Our Ref: BR/160/19/PL
Your Ref:

Town & Country Planning Act 1990 (as amended)
Town and Country Planning (Development Management Procedure) (England) Order 2015
Application for Planning Permission

Development Change of use from house in multiple occupation (C4 House in Multiple Occupation) to 4 No. self contained flats (C3 Dwelling houses).
Location Flat 1a 1 Queens Square Bognor Regis

Title
Plans+ Elevations as Proposed

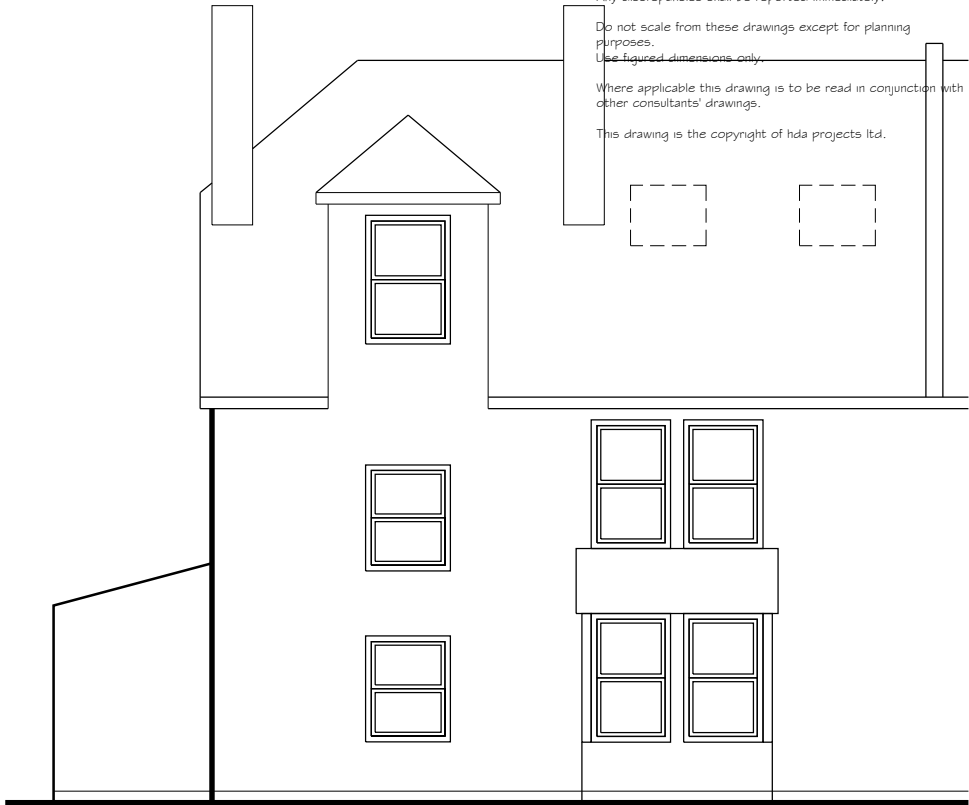
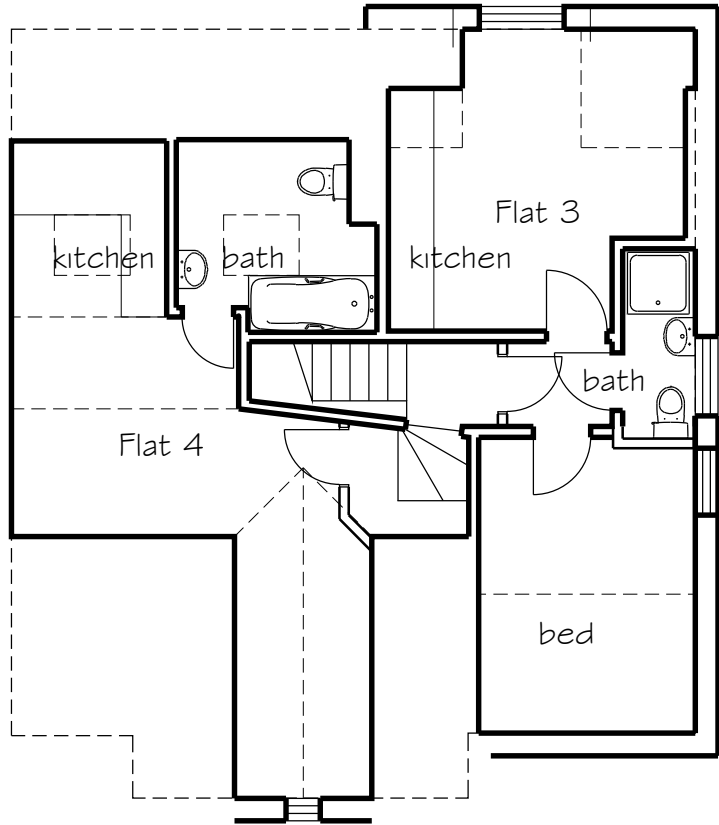
The existing and proposed second floor plan and north elevation do not accord. Please amend accordingly.
